**Re: Sunnica EN010106**

**Unique ref nos:AFP191**

### **Review of the Agricultural Land Classification of Sunnica's Lee Farm Site**

Sunnica Energy Farm Proposed Layout - (Predictive BMV Land Assessment)

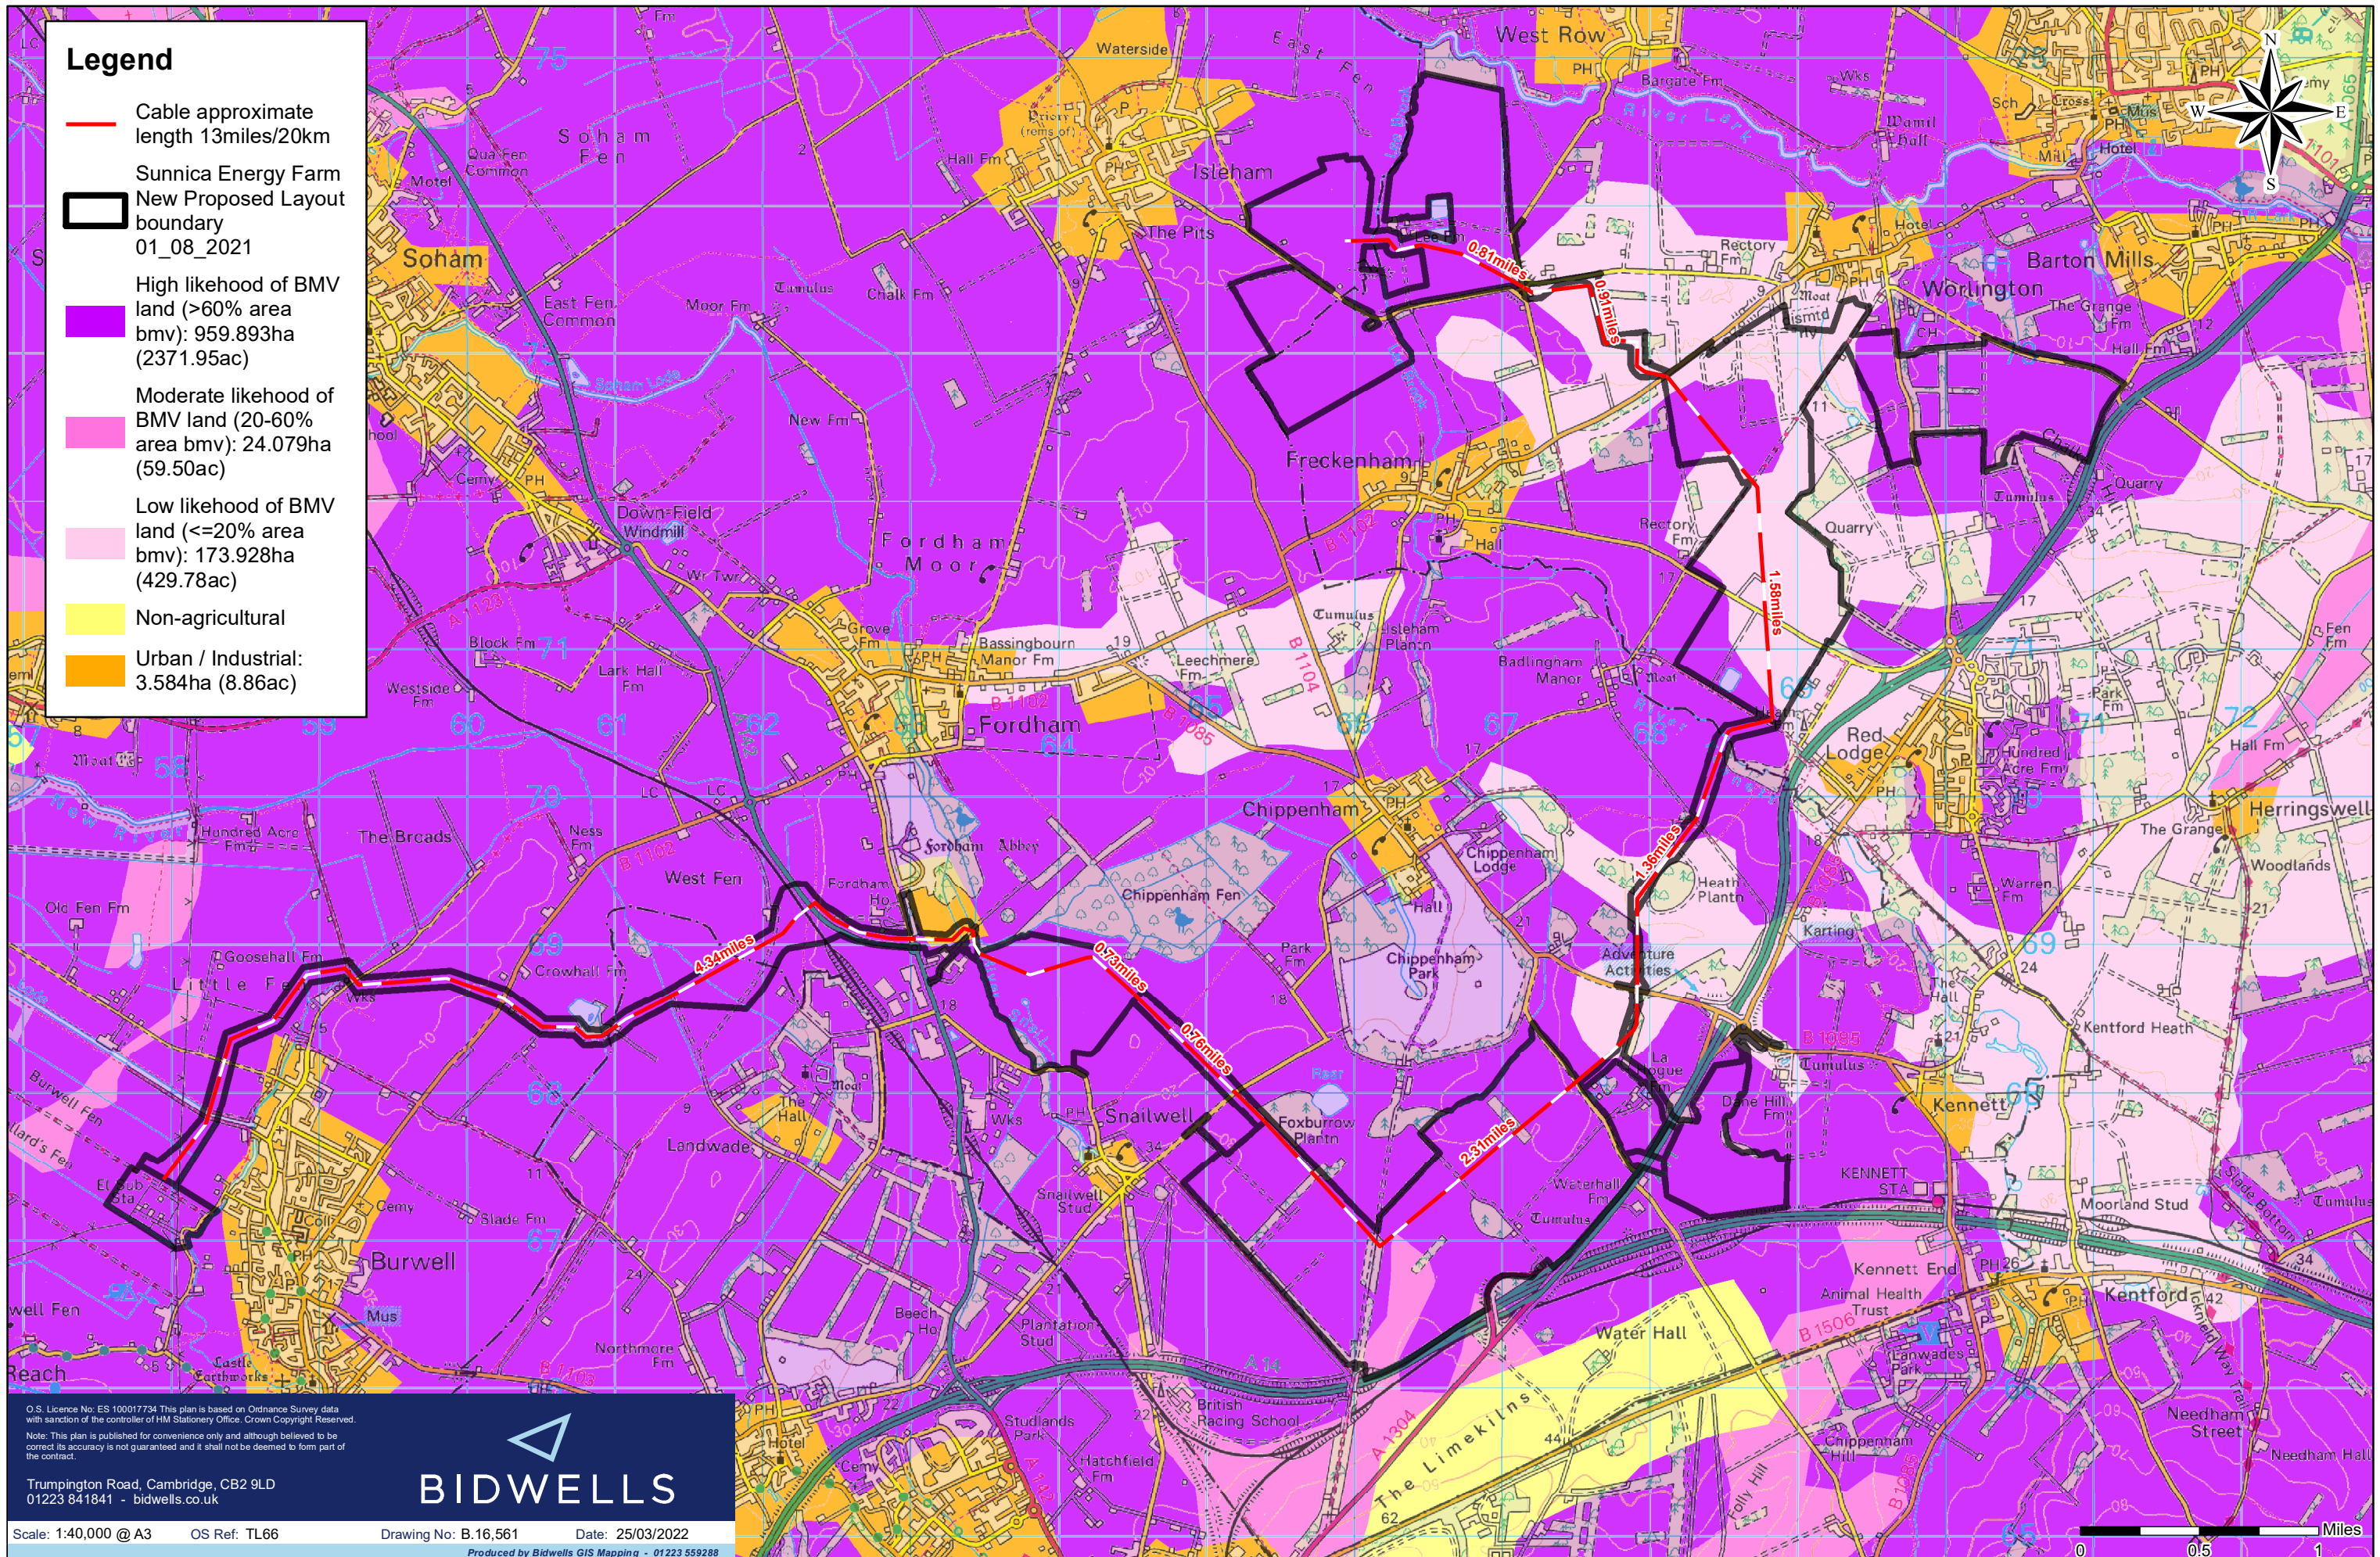
- b. Loss of BMV land: NE have incorrectly agreed that this scheme will not lead to a significant permanent loss of BMV. This is so in circumstances when they have not engaged with the criticisms of the DBSC approach in any proper way. In addition, NE have ignored their own predictive 2017 map which shows that 576 hectares are predicted to be BMV. My position is that this is a more accurate view of the BMV land, supported by detailed surveys and maps from the soil survey. NE have not engaged with this nor required DBSC to justify the massive difference between their own predictive mapping and their assessment in this case.

Natural England's own predictive map of ALC marks the whole area as having a better than 60% probability of being best and most versatile (BMV).
